WINDERMERE FILING NO. 2

EROSION CONTROL AND STORMWATER QUALITY PLAN

EPC STORMWATER REVIEW COMMENTS ARE SHOWN IN ORANGE BOXES WITH BLACK TEXT

SP-22-003

**INITIAL/INTERIM
EROSION CONTROL
PLAN**

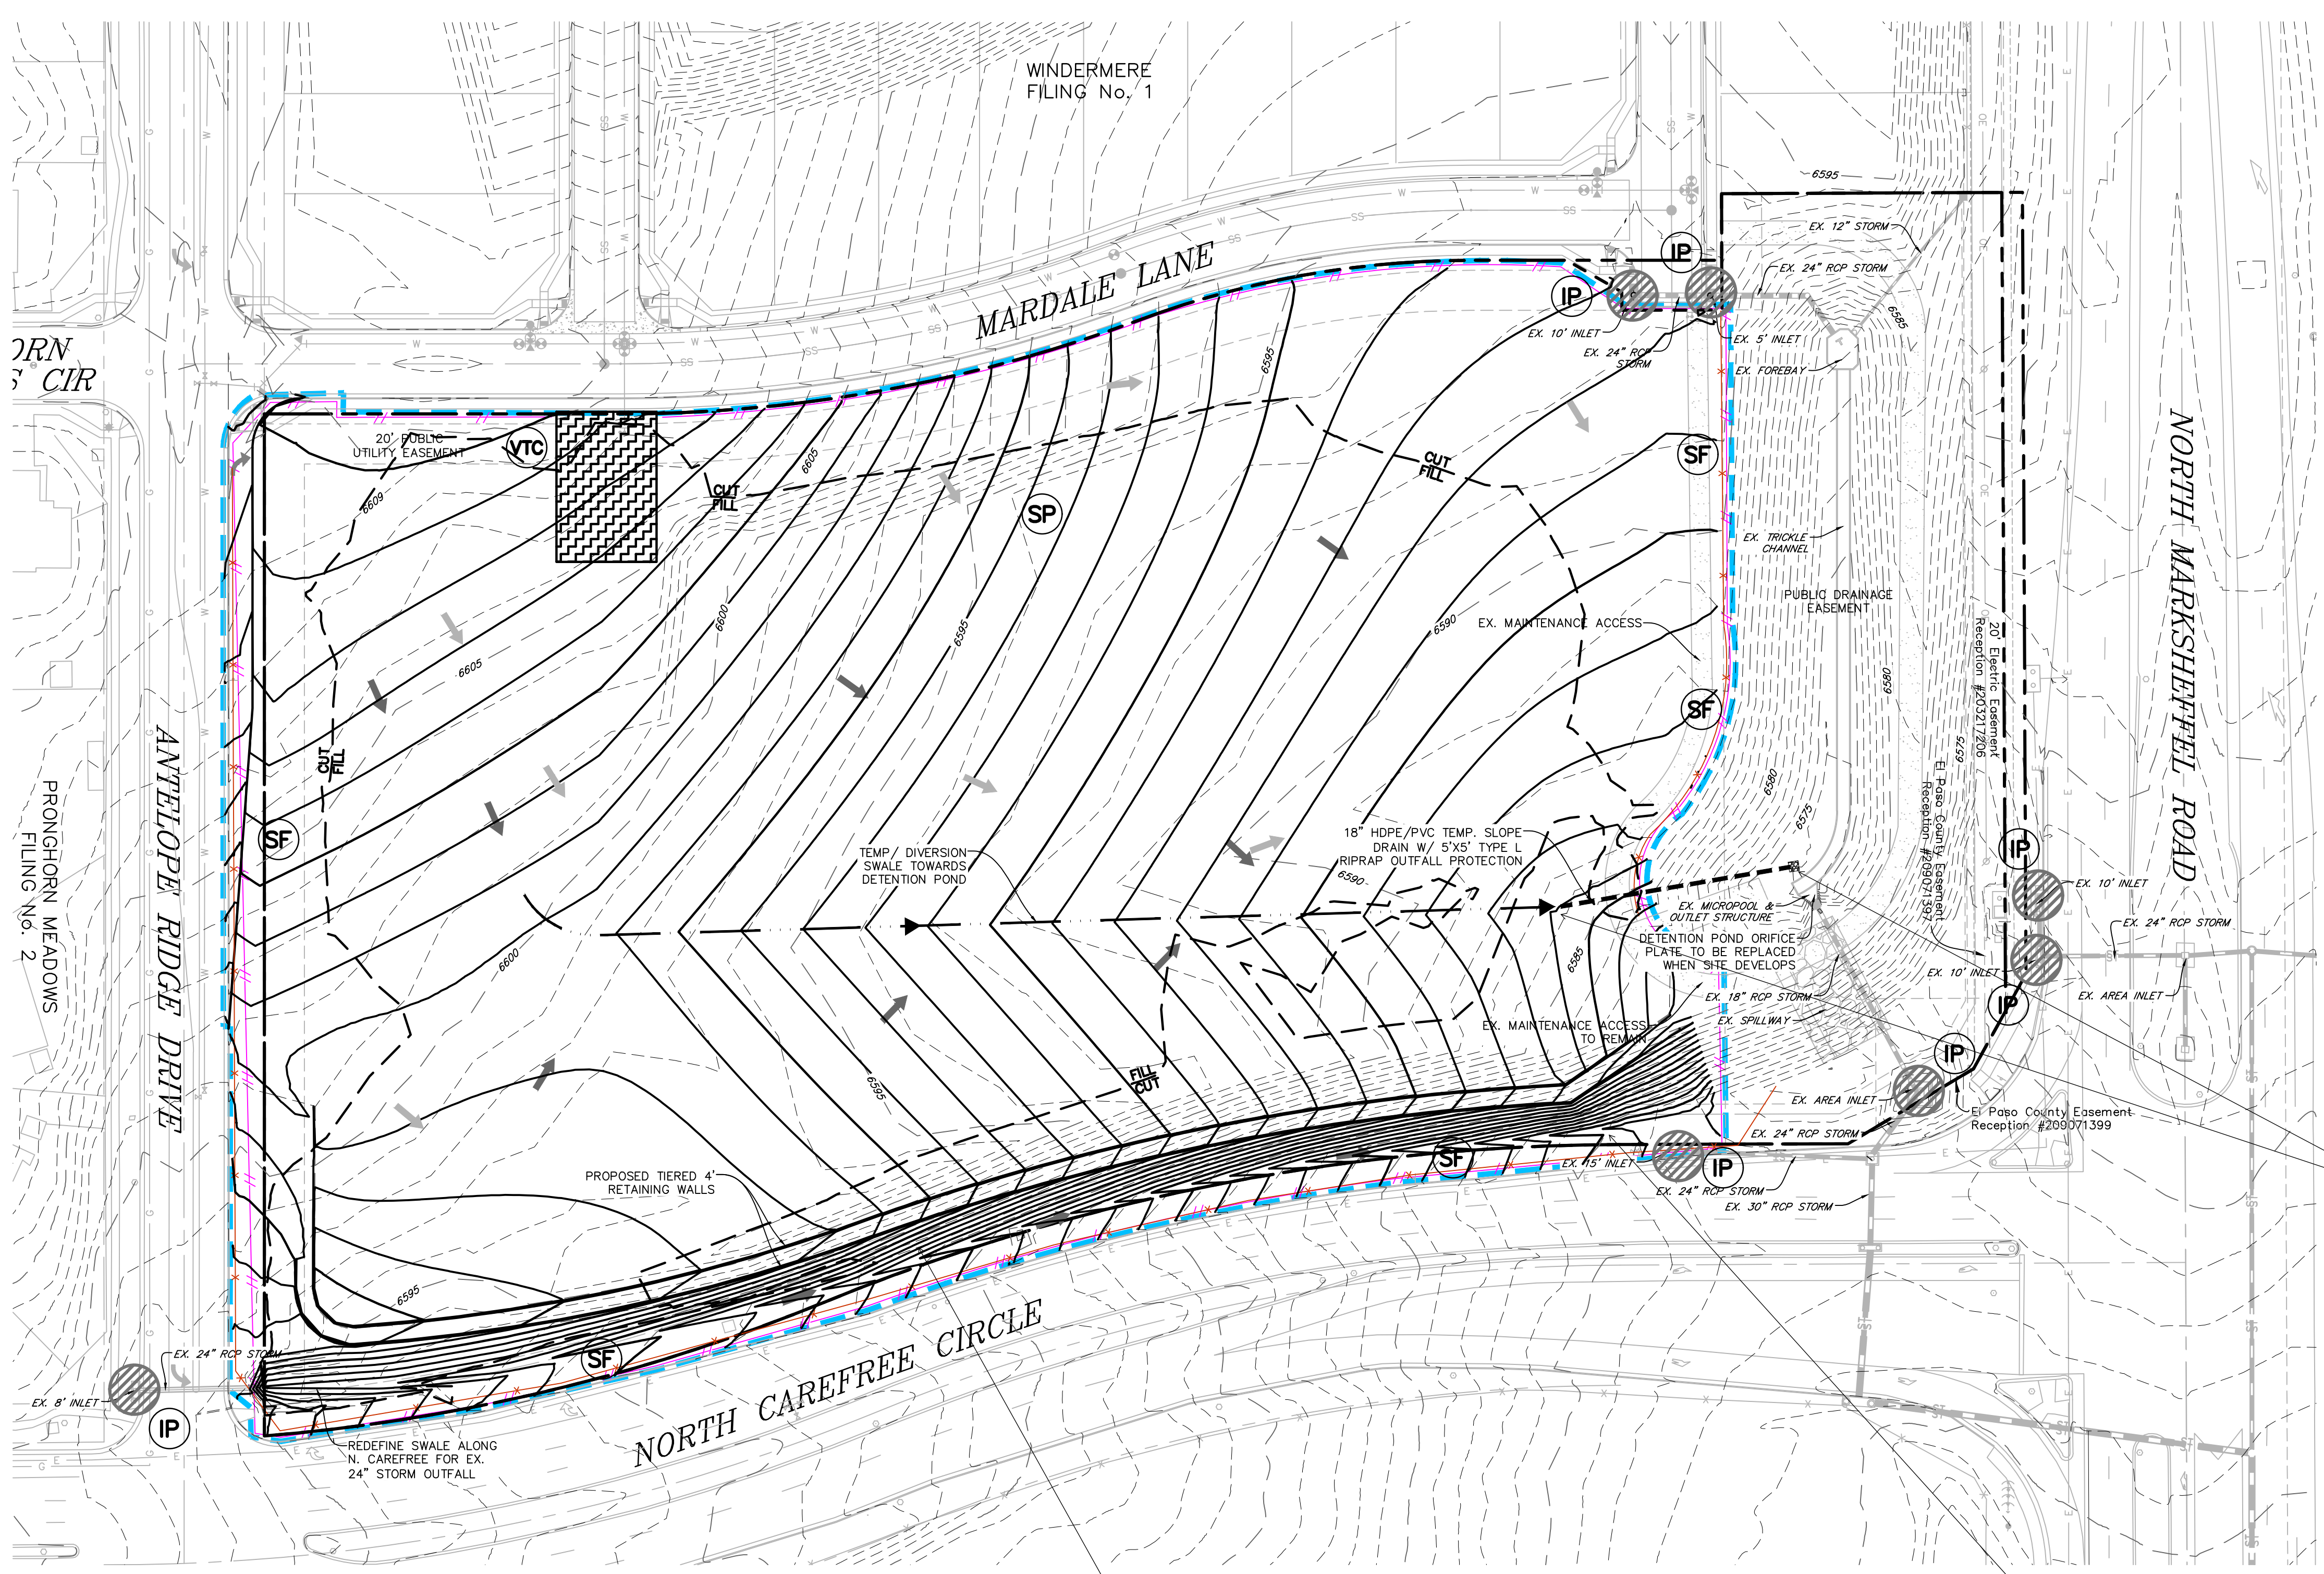
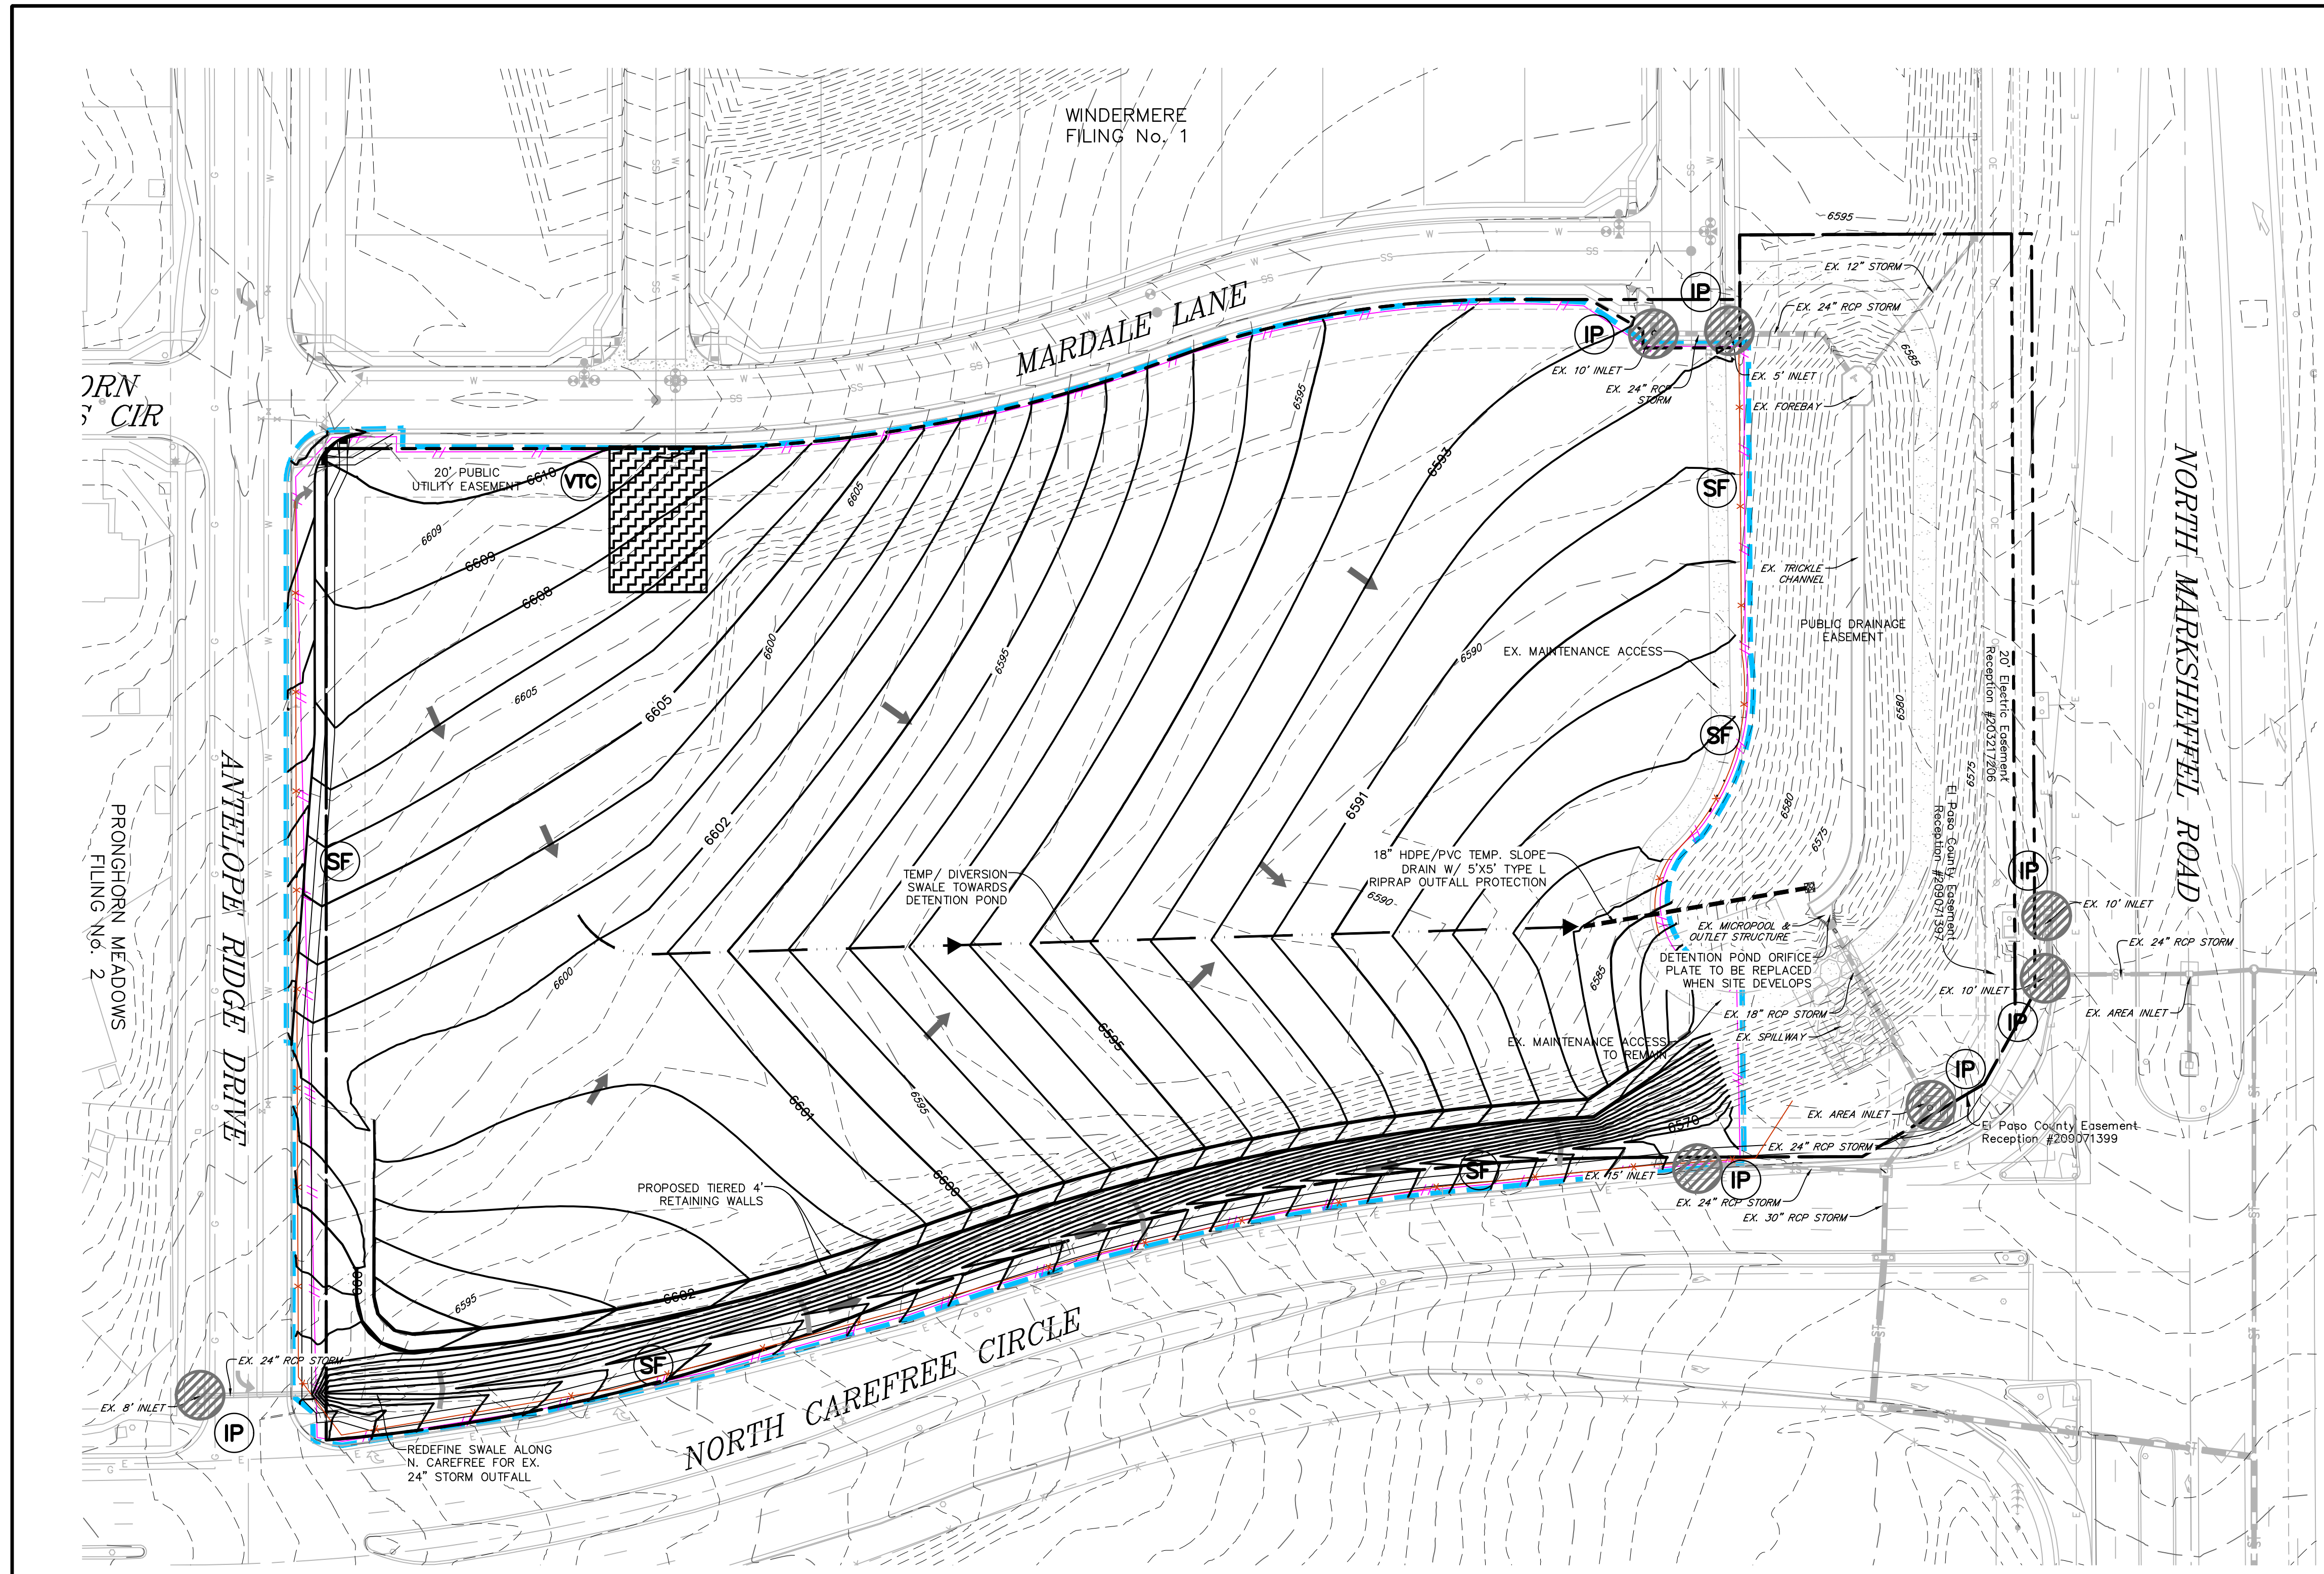
Item W. Provide construction fencing, barricades, and/or signage at access points not to be used for construction.

Proposed roads and storm drain shouldn't be shown for early grading initial BMPs

Item p. Show all areas of cut/fill

To comply with the SWMP Checklist Item 17f, please add a note stating no batch plants will be utilized onsite.

please separate initial and interim BMPs onto two separate sheets
